WEST SUSSEX COUNTY COUNCIL CONSULTATION

TO:	Arun District Council FAO: Anita Gardner
FROM:	WSCC - Highways Authority
DATE:	11 November 2020
LOCATION:	128 Sea Road East Preston BN16 1NN
SUBJECT:	EP/125/20/PL Alteration & extensions to flat to create 2 No. one-bedroom self contained flats including loft conversion and dormers (as approved EP/41/19/PL). This site is in CIL Zone 4 & is not CIL Liable as new flat.
DATE OF SITE VISIT:	n/a
RECOMMENDATION:	Advice
S106 CONTRIBUTION TOTAL:	n/a

PROPOSED

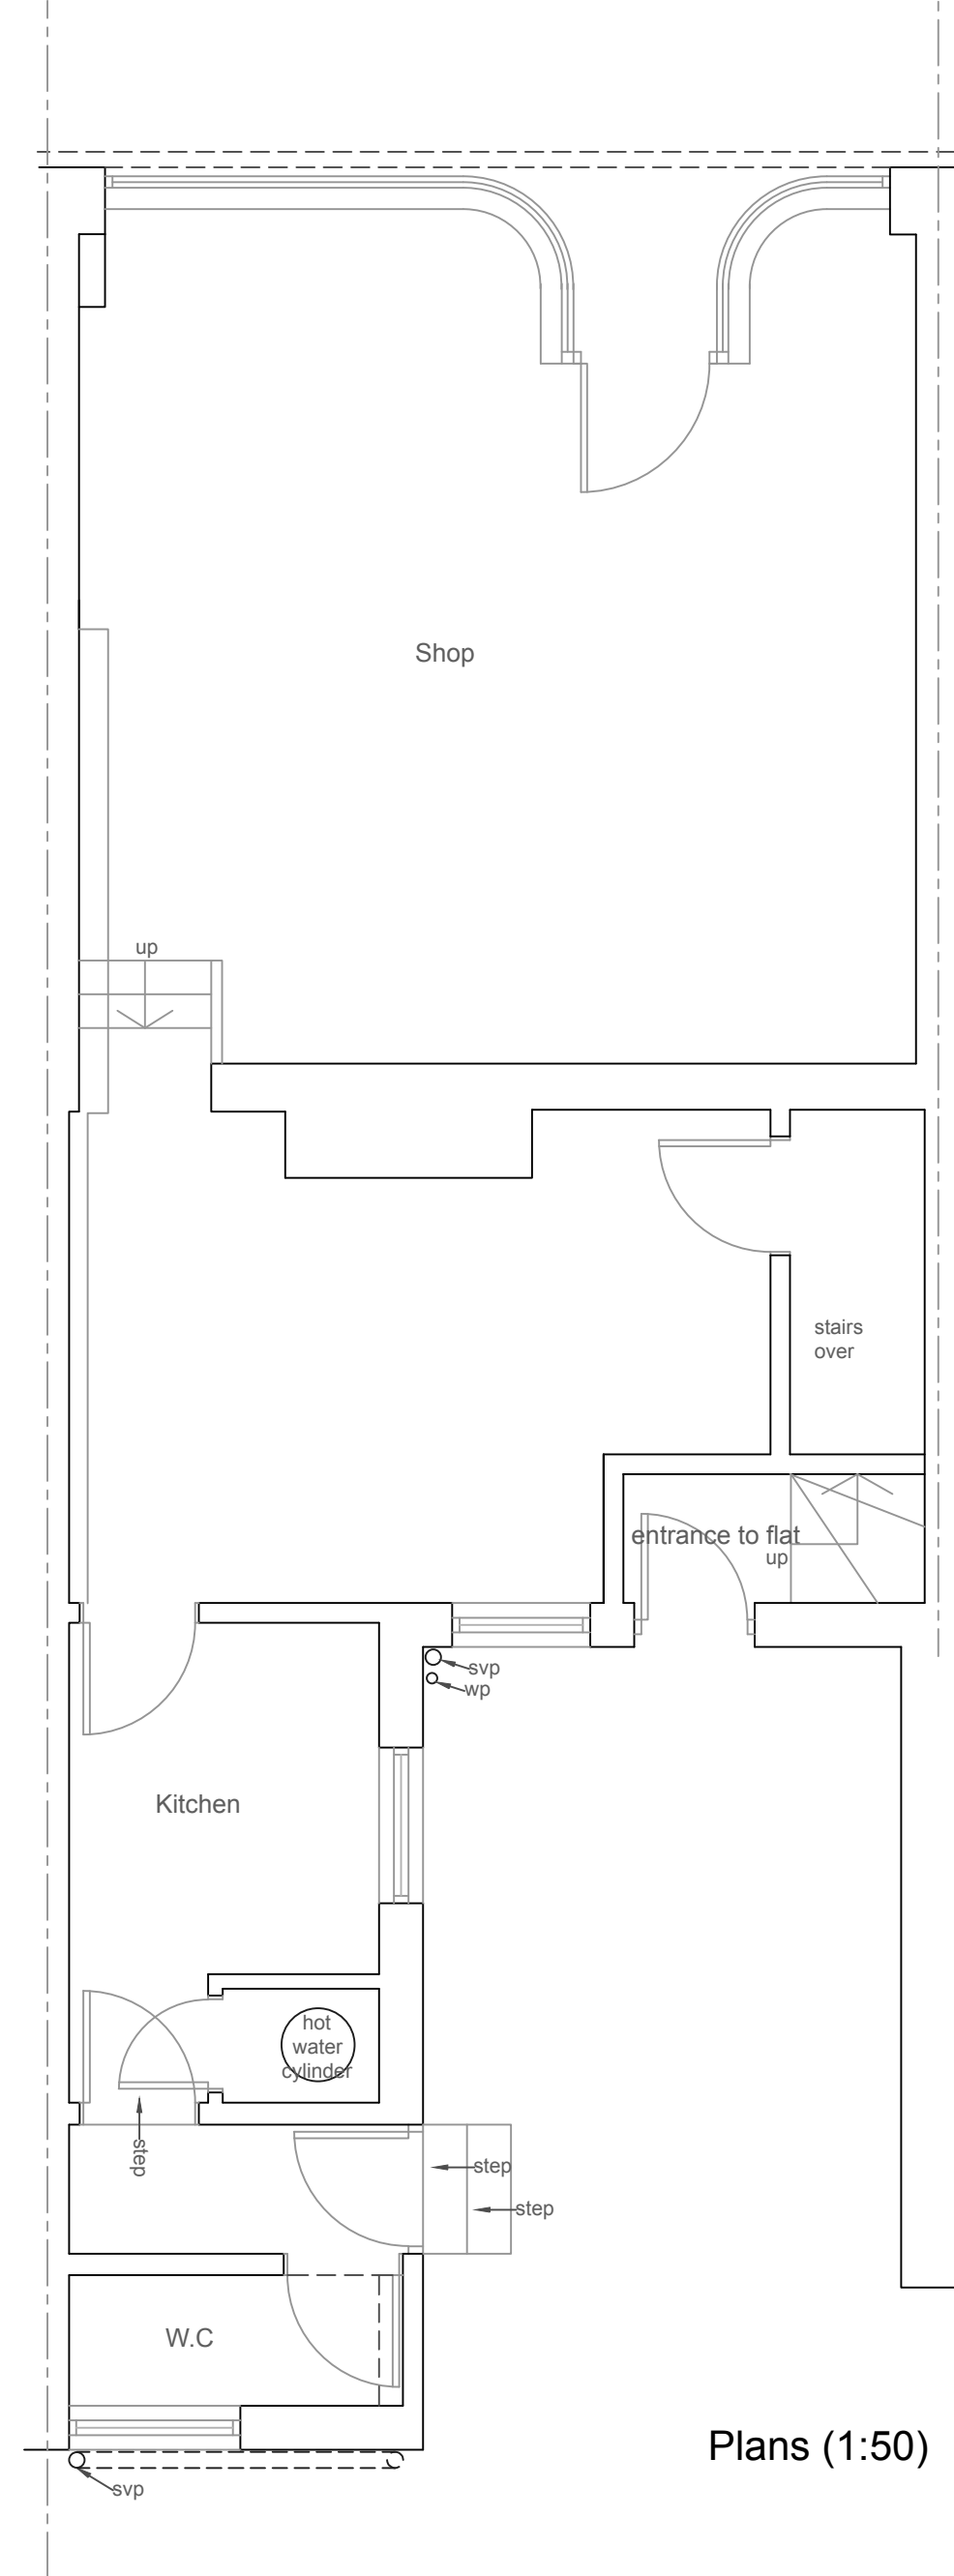
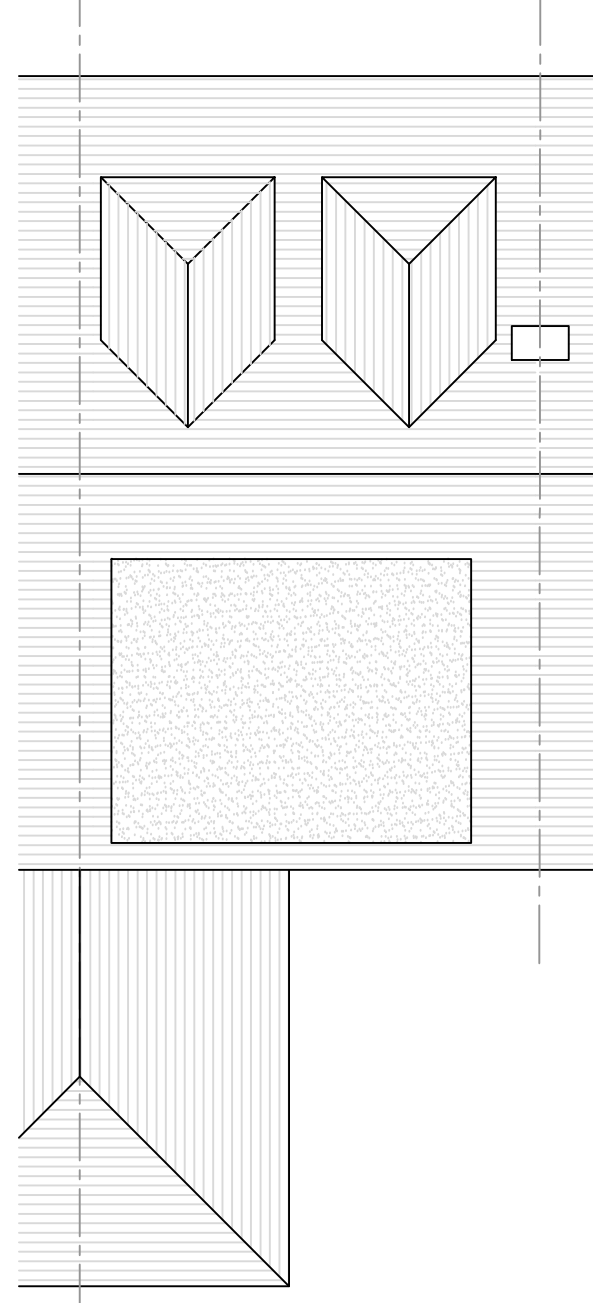
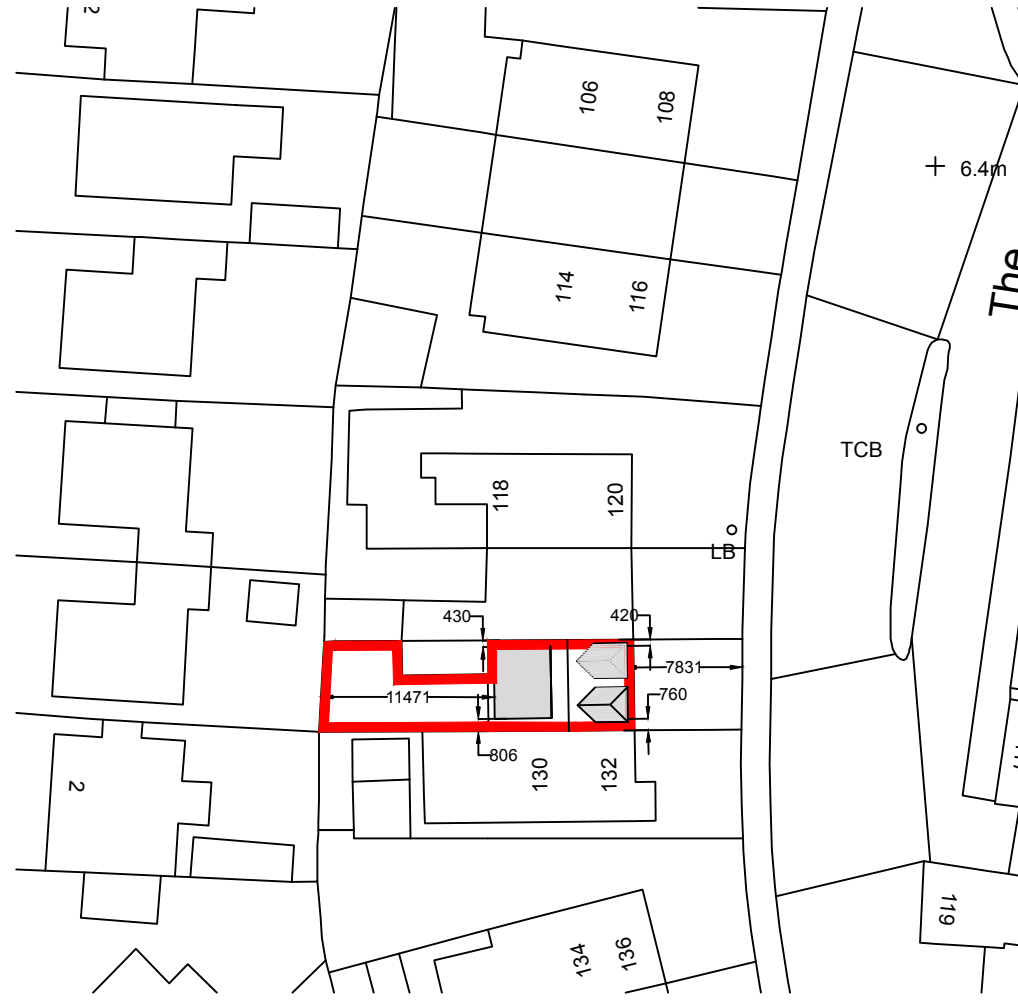
The applicant proposes a NIL car parking provision for the new flats. Under the Arun Parking Standards (adopted January 2020), the applicant should provide 2 car parking spaces for the proposal.

The applicant has proposed a NIL cycle parking provision, the LHA advises the Local Planning Authority (LPA) that if they deem cycle parking justifiable then the applicant should show this in the form of lockable covered storage. Details of which can be secured with a suitably worded condition found below.

No part of the development shall be first occupied until covered and secure cycle parking spaces have been provided in accordance with plans and details **to be** submitted to and approved by the Local Planning Authority.
